File No: NTH18/00047/11  
Your Ref: SSD10353

**Re: Review of EIS for Tweed Valley Hospital – Stage 2. - Major Project SSD10353.**

I refer to your email dated 4 October 2019 requesting comment from Roads and Maritime Services in relation to the above mentioned EIS for the construction of the Tweed Valley Hospital (stage 2 of the project).

PROPOSED KERB & GUTTER

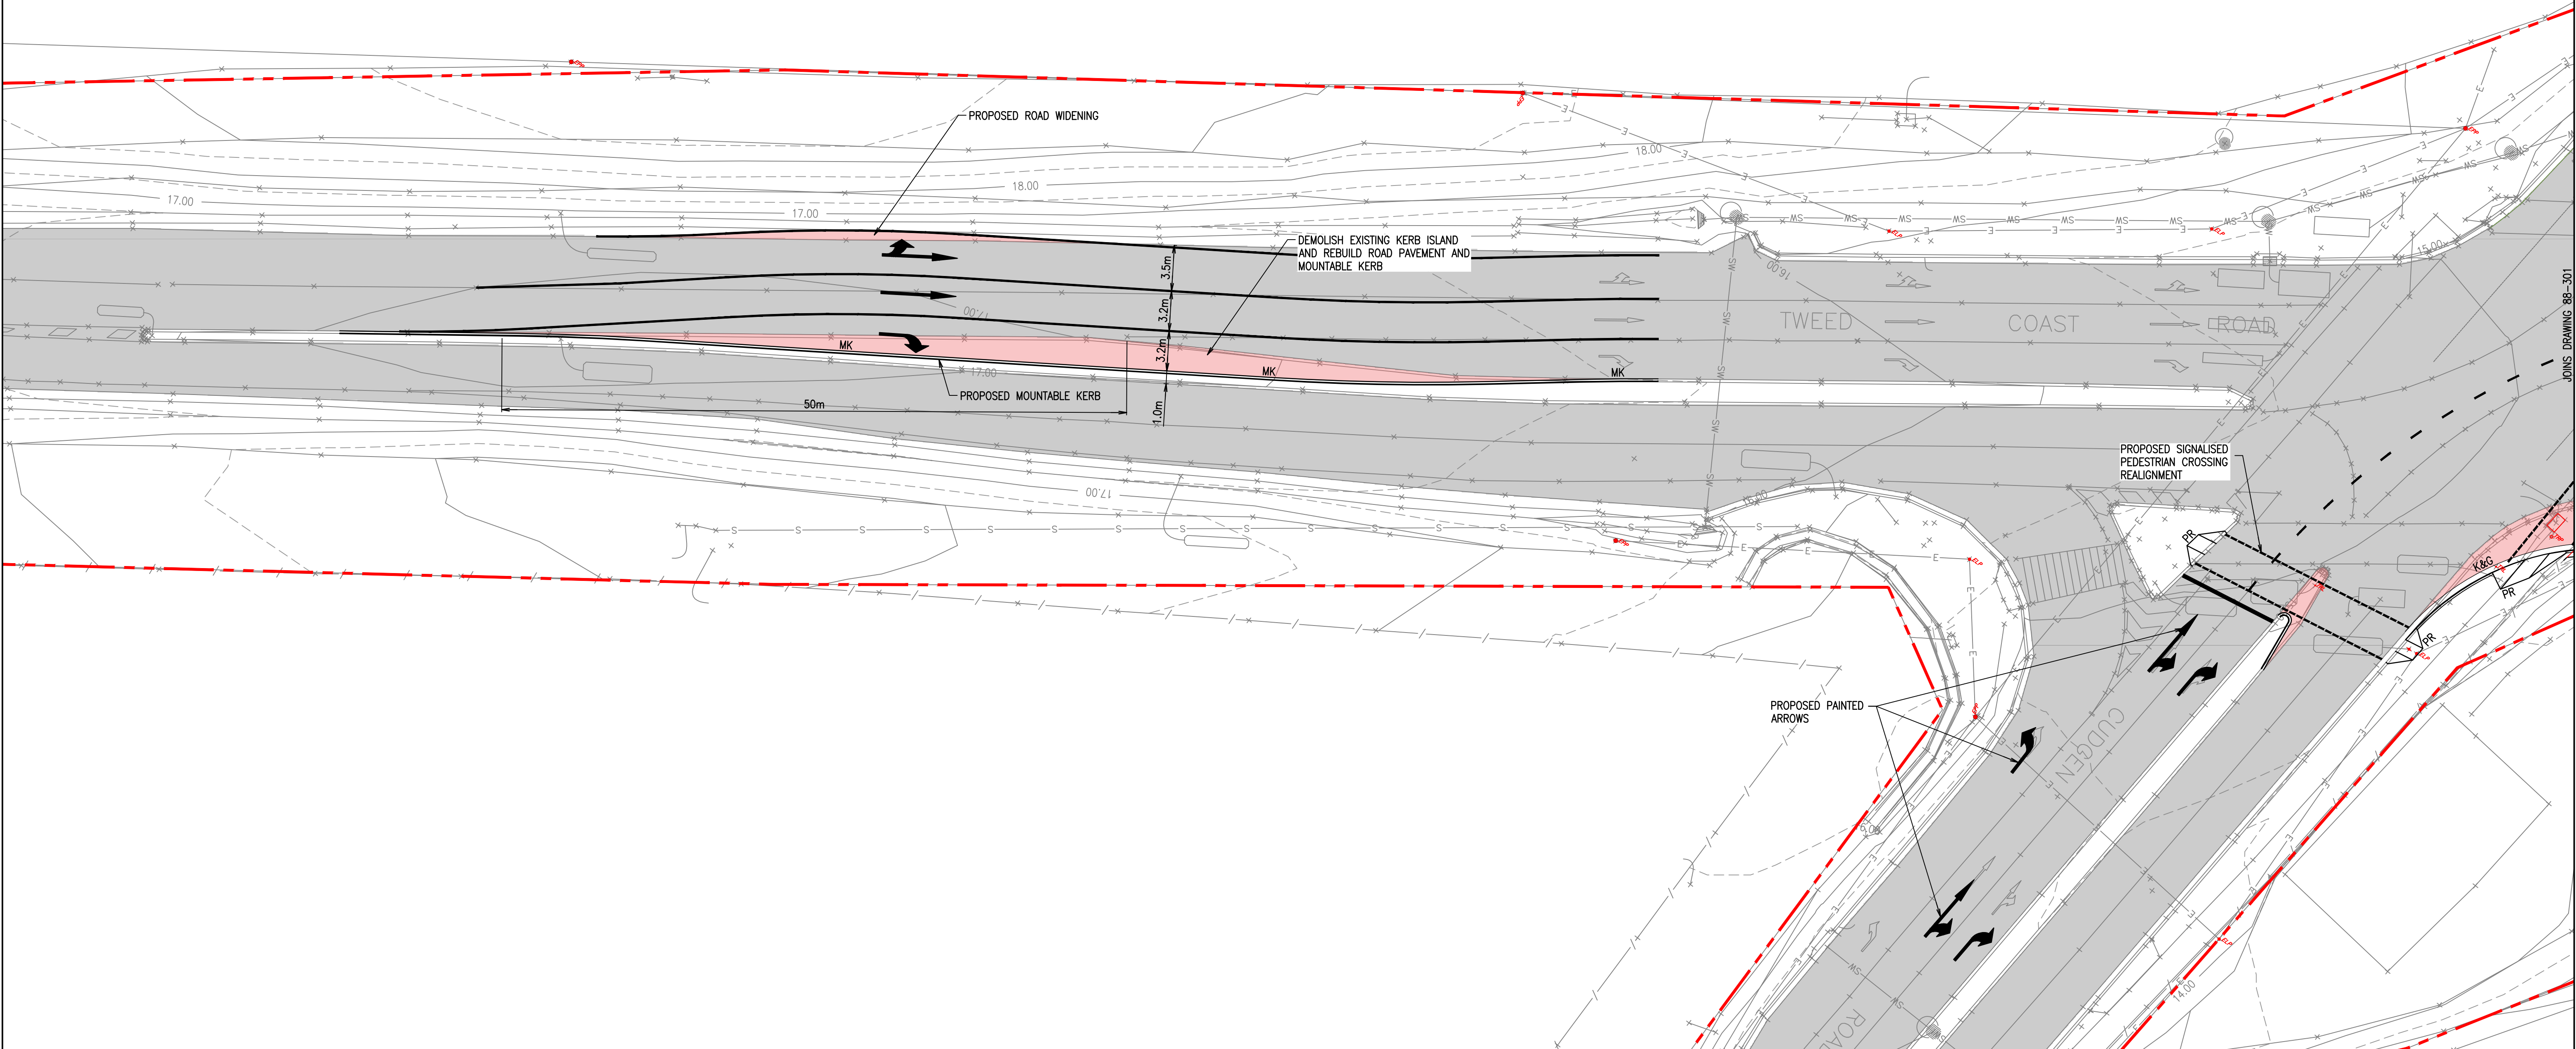
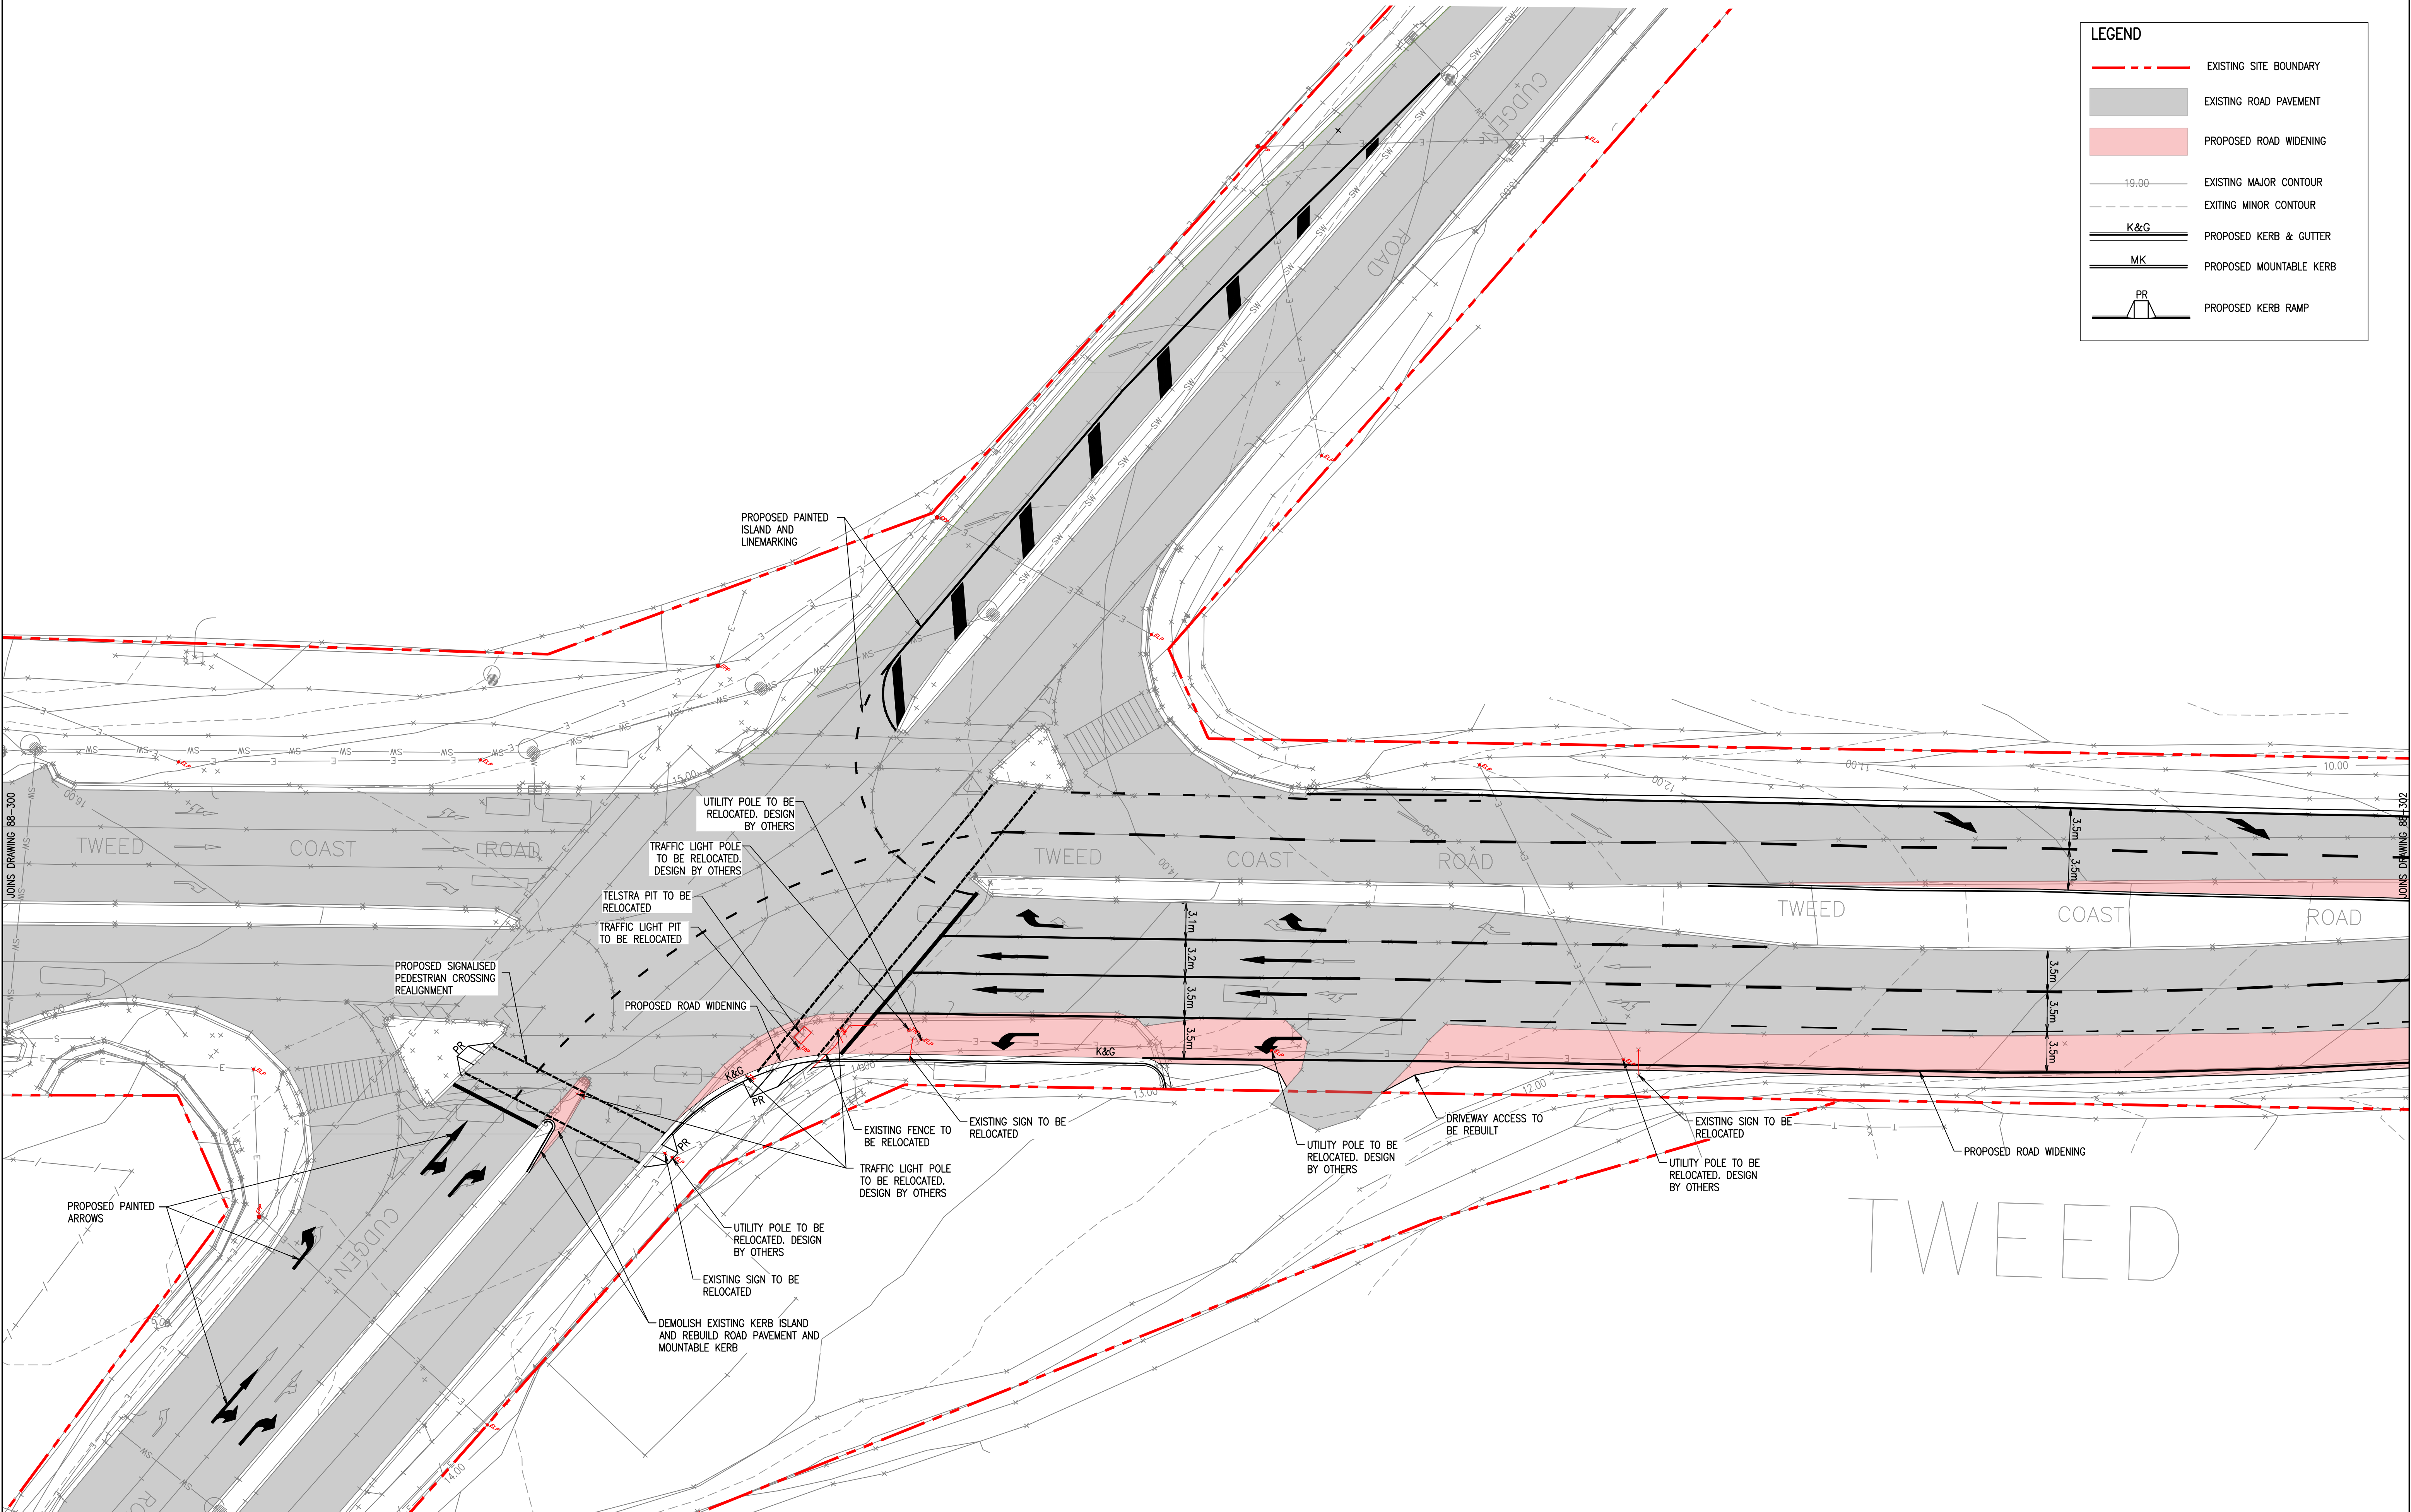
- Stage 1 consent condition B22 (c) requires plans for the upgrade for Tweed Coast Road/Cudgen Road intersection. The plans provided for stage 2 have no dimensions and should be updated to include the additional lengthening of the Tweed Coast Road north-bound right-turn bay, and left-turn deceleration lanes on Cudgen Road. No detailed plans were provided for the proposed traffic signals at the Hospital entrance.

- Left-turn lanes at the Tweed Coast Road/Cudgen Road at the access into the Hospital should be designed in accordance with Austroads standards. They should be long enough to cater for deceleration and queued traffic due to pedestrian crossings or internal design. For a 60km/h speed zoned area, this would require a minimum of 55m plus queue length.

- Modelling provided with the Stage 2 EIS has indicated that only 20m storage was required for the east-bound left-turn deceleration lane. This should be lengthened to provide 55m to cater for deceleration and queuing back from the hold line as only a single entry lane is provided for both left and right-turning entering traffic into the site. This change should also apply to the four other left-turn slip lanes (east-bound left-turn lane at Tweed Coast Road signals; and the three along the frontage of the site).

- The existing left-turn slip lane for vehicles turning from the western approach to Cudgen Road into Tweed Coast Road has limited storage. SIDRA modelling indicates that this lane needs to provide more capacity. Any queuing will have a significant impact on through and right-turn traffic. It is noted that the northern side is constrained by existing residential. It is suggested that strategic drawings be provided to show queue lengths, and that Council/State Government confirm that those lengths are acceptable and meet Austroads standards.
